**STATE SIGNIFICANT
DEVELOPMENT
APPLICATION**

ADDENDUM

**VOL 5 – RESPONSE TO
PLANNING QUERIES**

25 MOSS VALE ROAD, BOMADERRY
JANUARY 2026 – UPDATE V3

Drawing Title  
 Housing Site C - Proposed SSDA  
 Site Plan

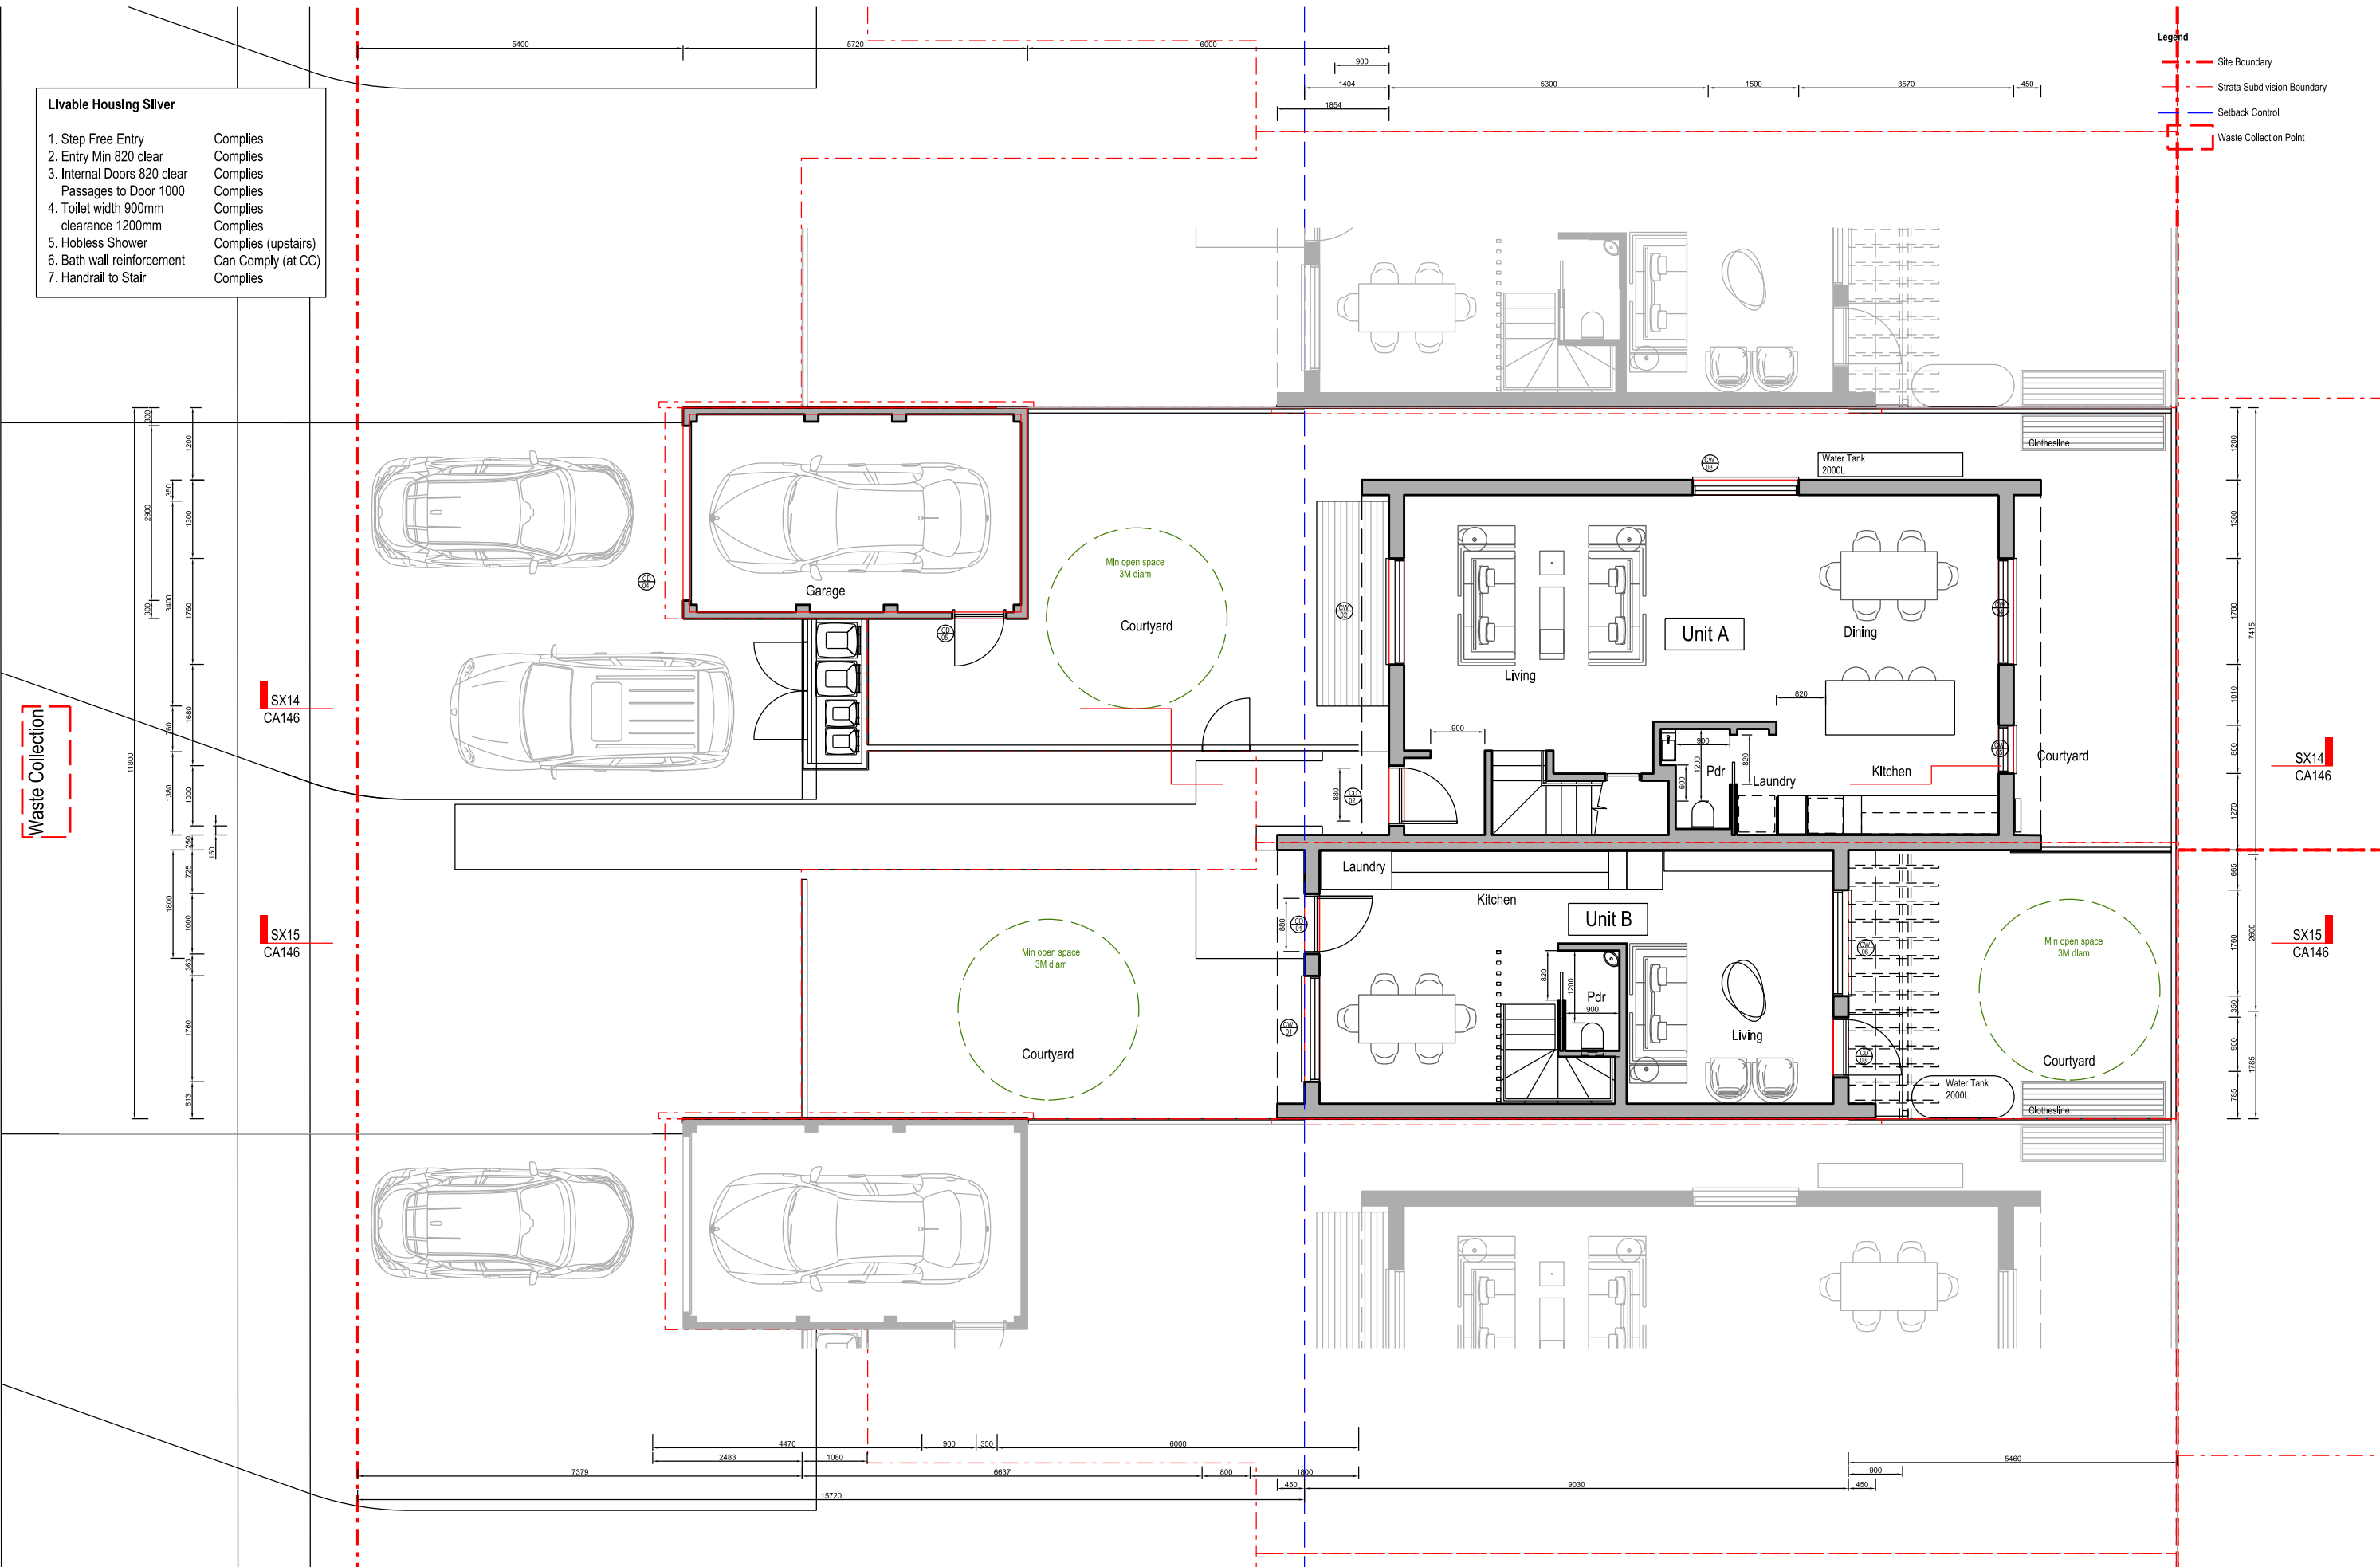
NSW Planning have requested clarification of the titling and subdivision of the Multi Dwelling Housing in Precinct C. The Strata Subdivision has been clarified on the site plan CA100 illustrating that the group is treated as 6 units of Multi Dwelling Housing on each site (C1 and C2), with each having a strata lot containing the unit and private open space area. The external off-street parking and street frontage open space is proposed as common area. This complies with the definition of Multi Dwelling housing as there are more than 3 dwellings on each site which we understand to be permissible in accordance with the SLEP2014.

Drawing Title
Site L - Maintenance Workshop - SSDA
Site Plan

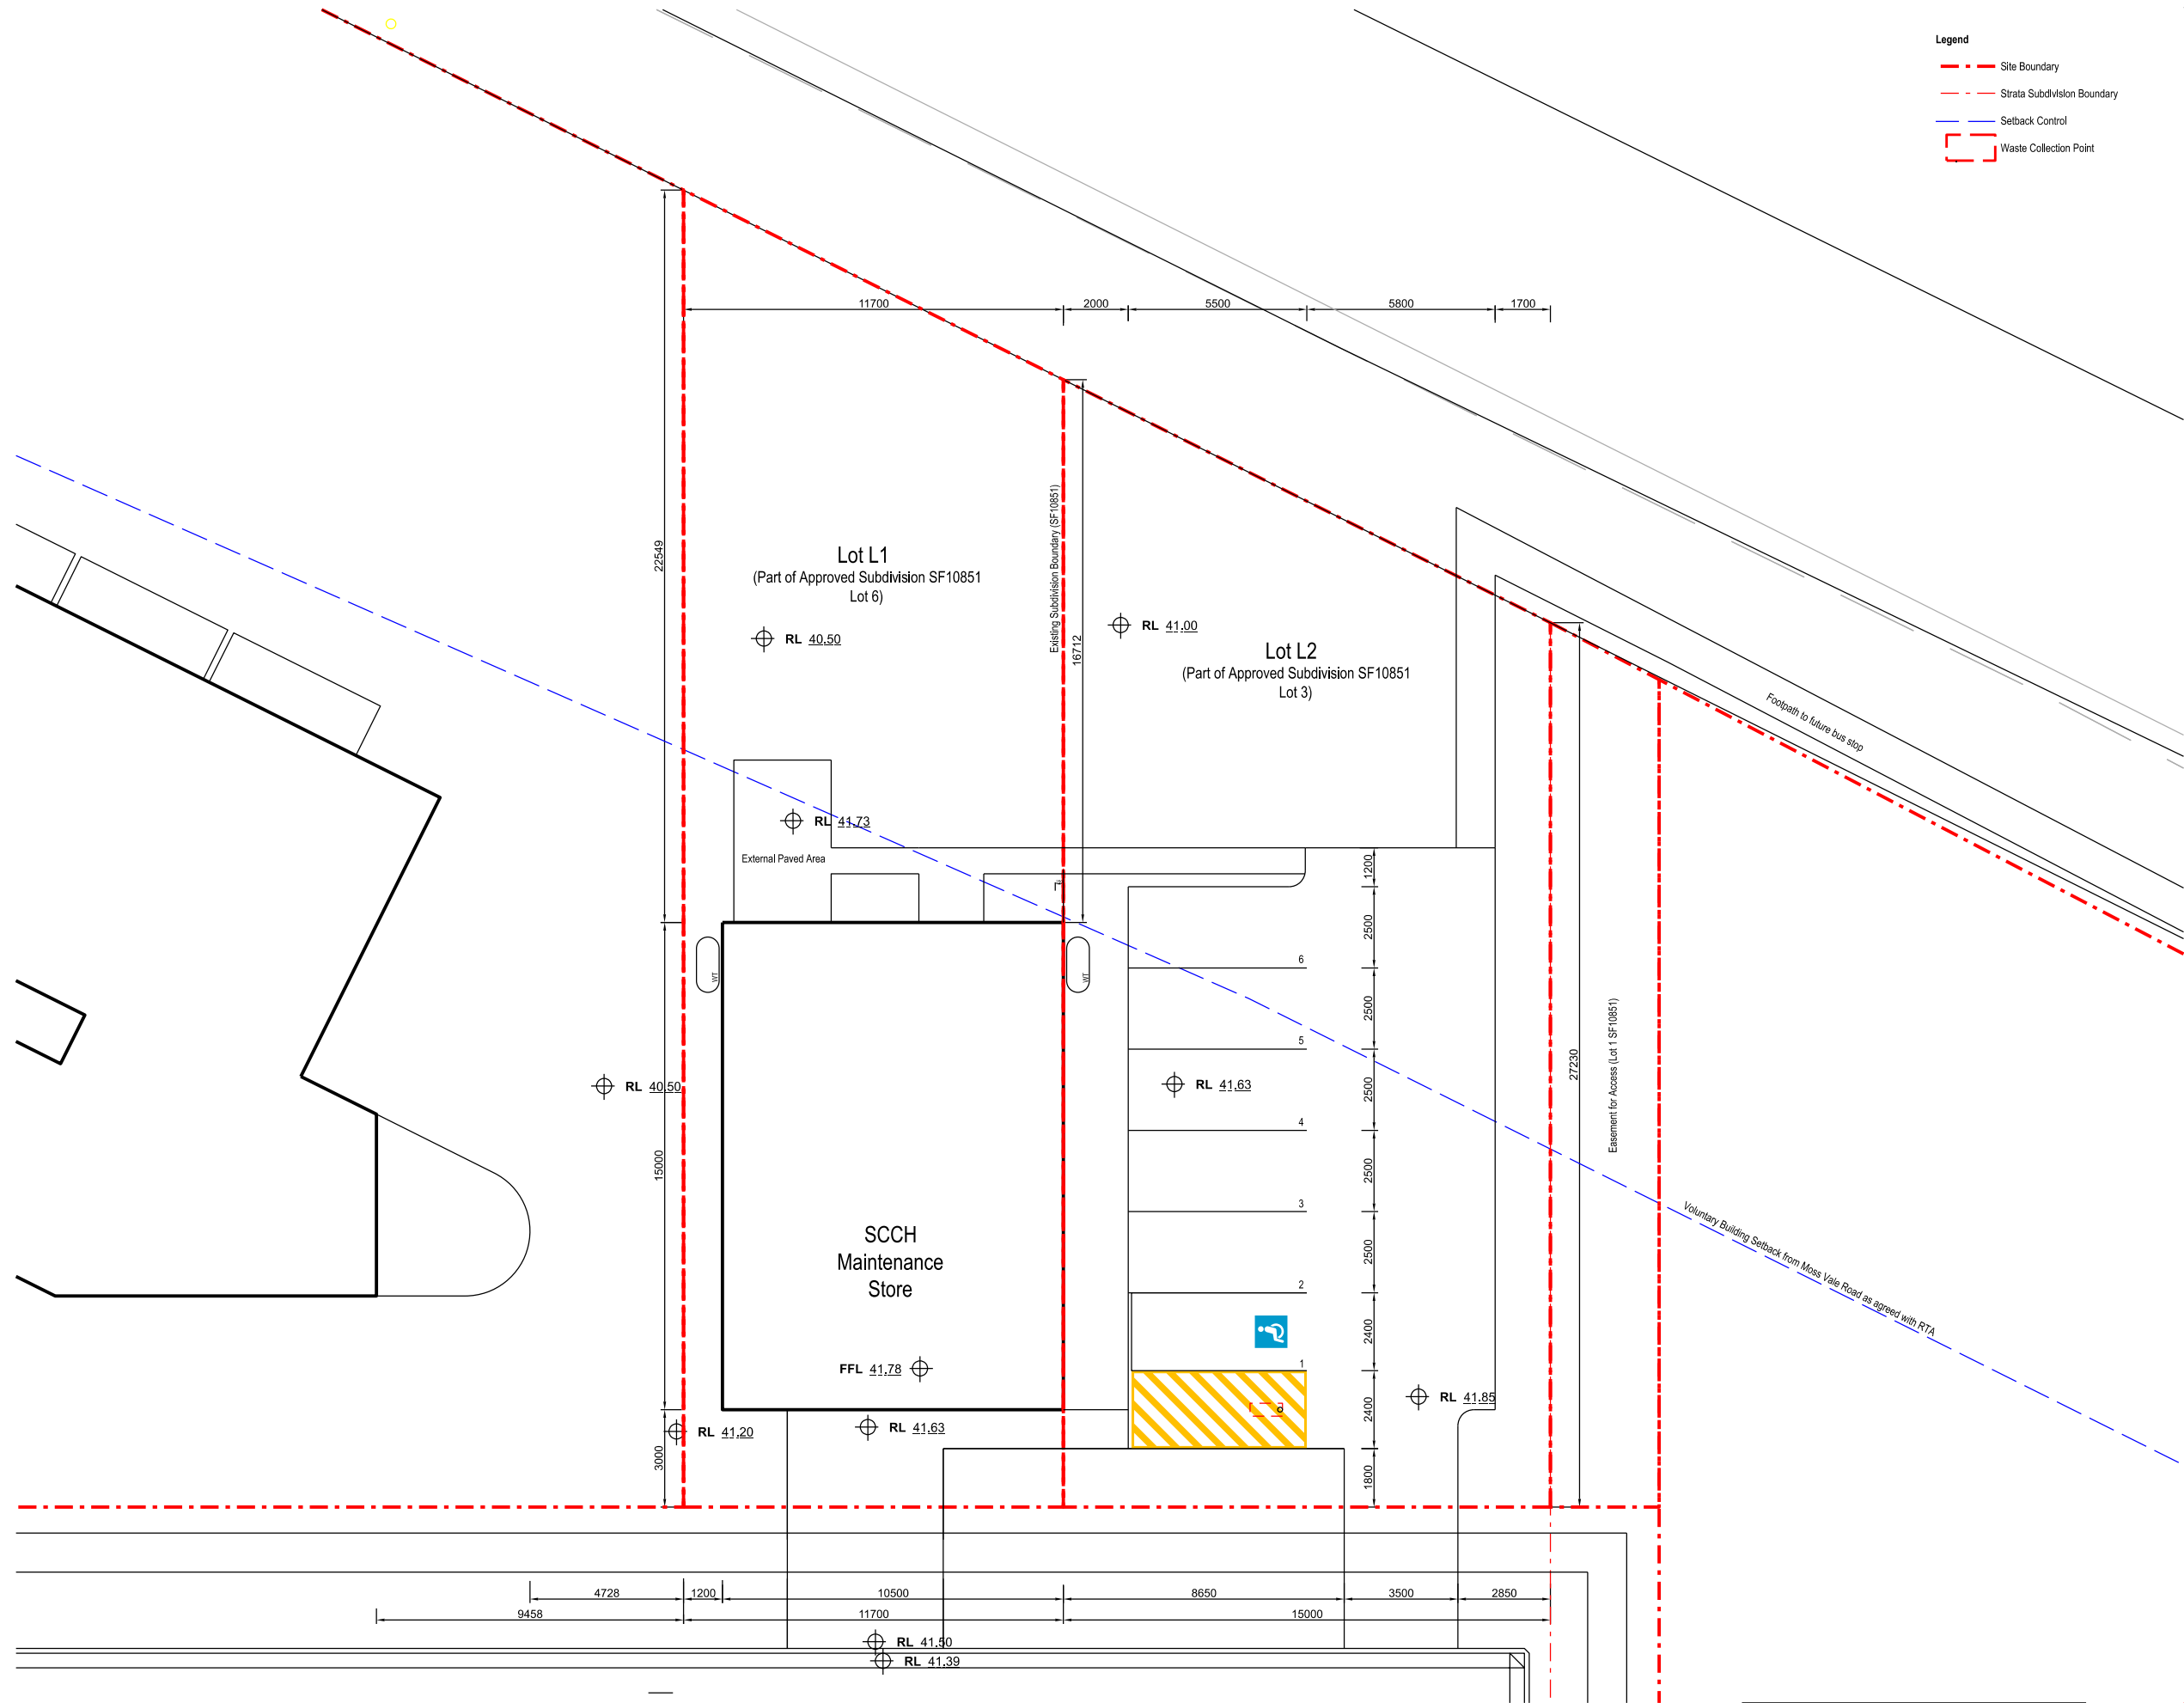
7. SITE PLANS

Site Plans are included within the updated drawing packages, specifically Drawings:

LA100

Drawing Title
 Housing Precinct E - SSSA
 Solar Access Assessment

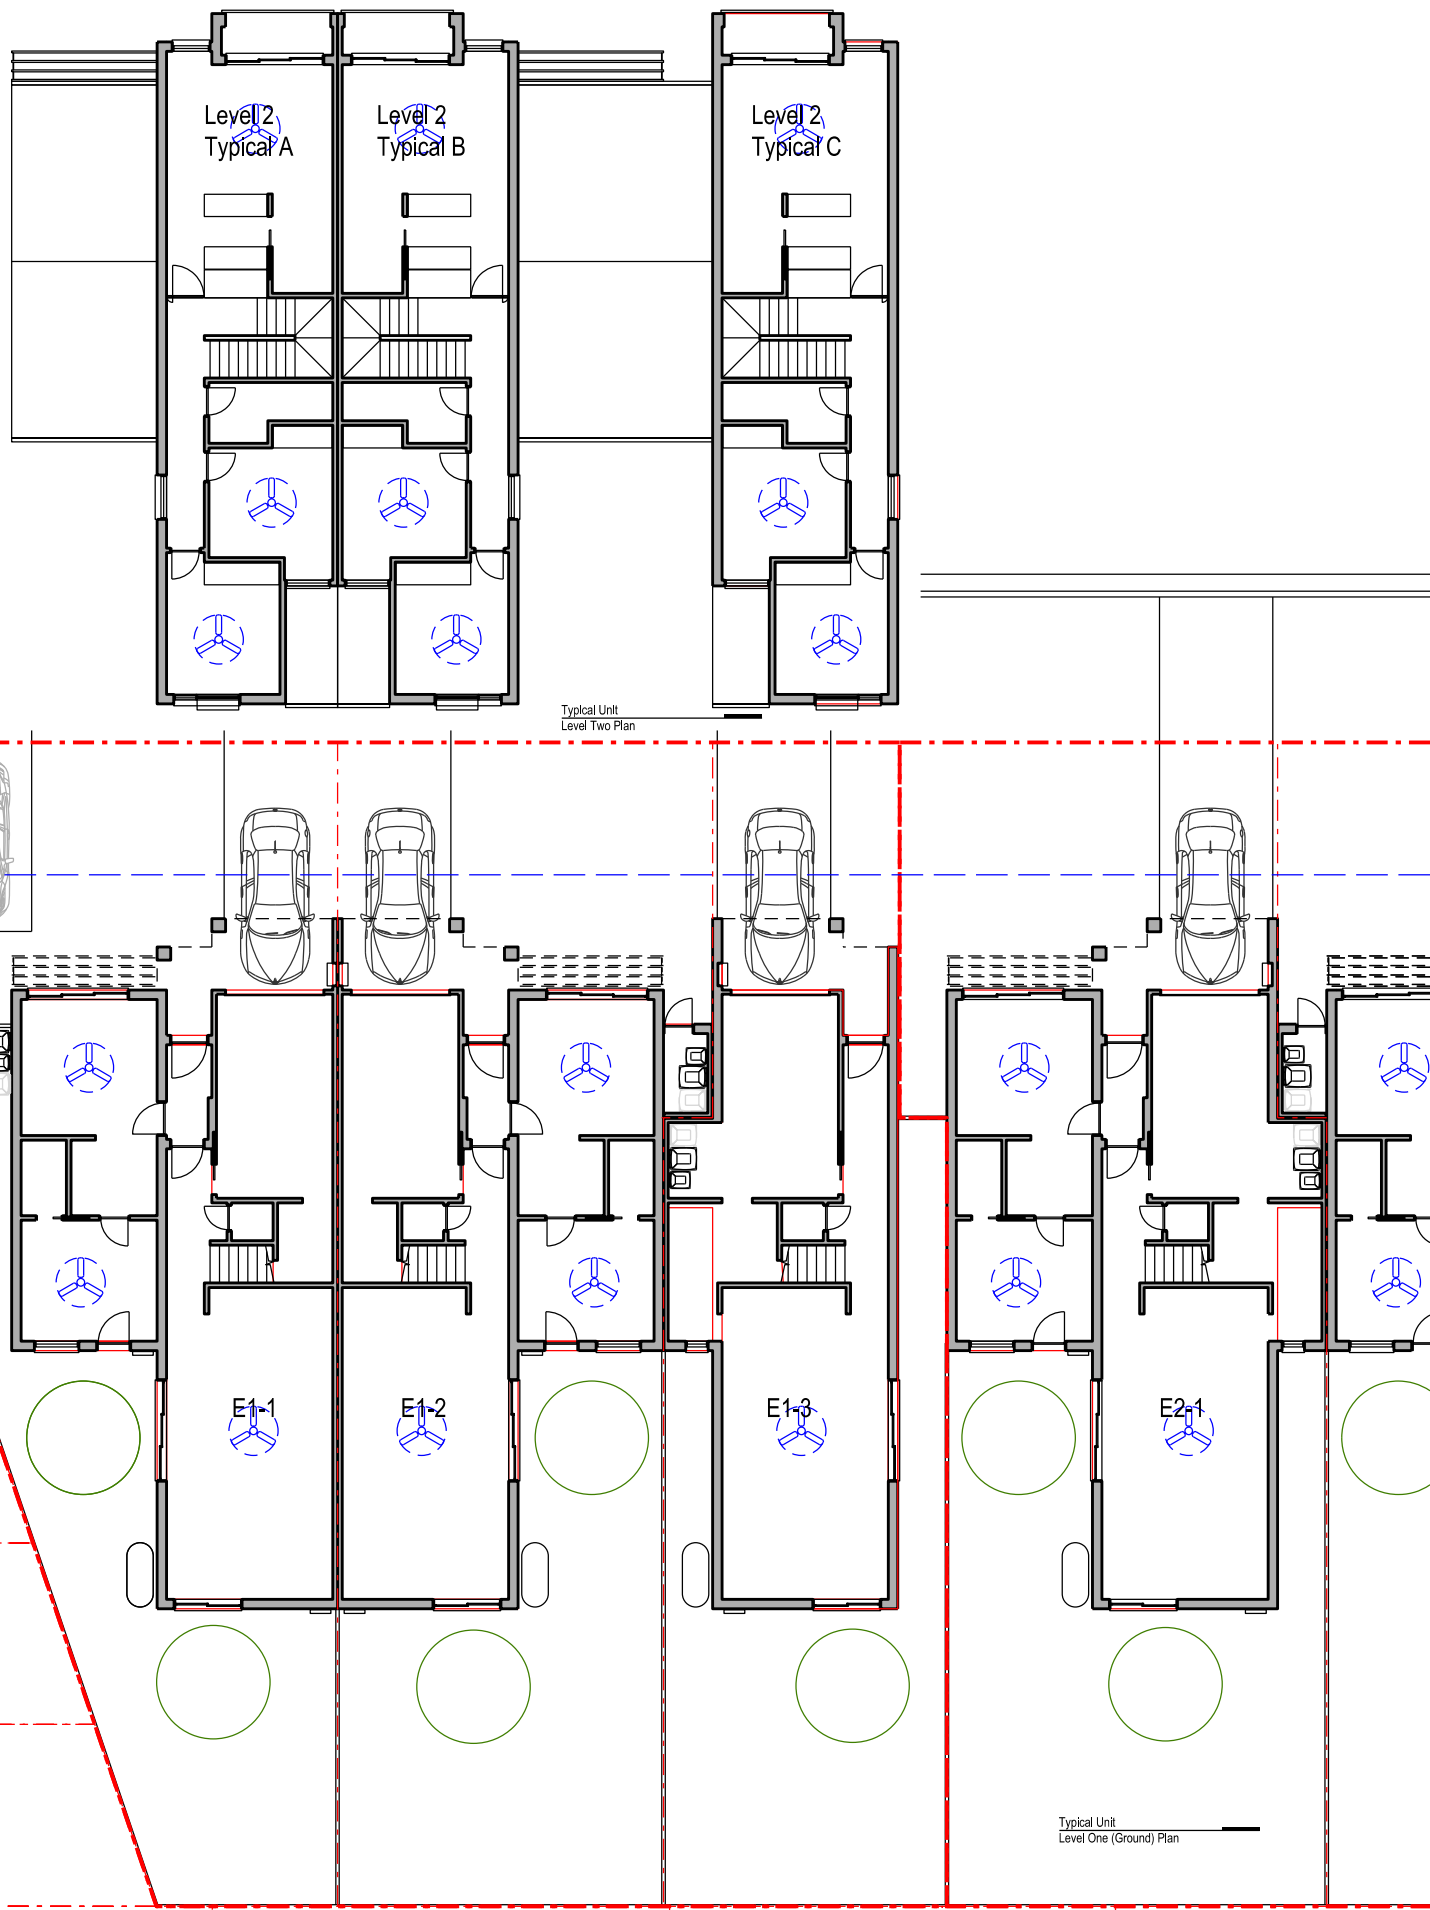
e. Solar Access

Solar access for the Class 1 Dwellings has been included in the precinct drawing packages. Refer to Drawings Numbers:
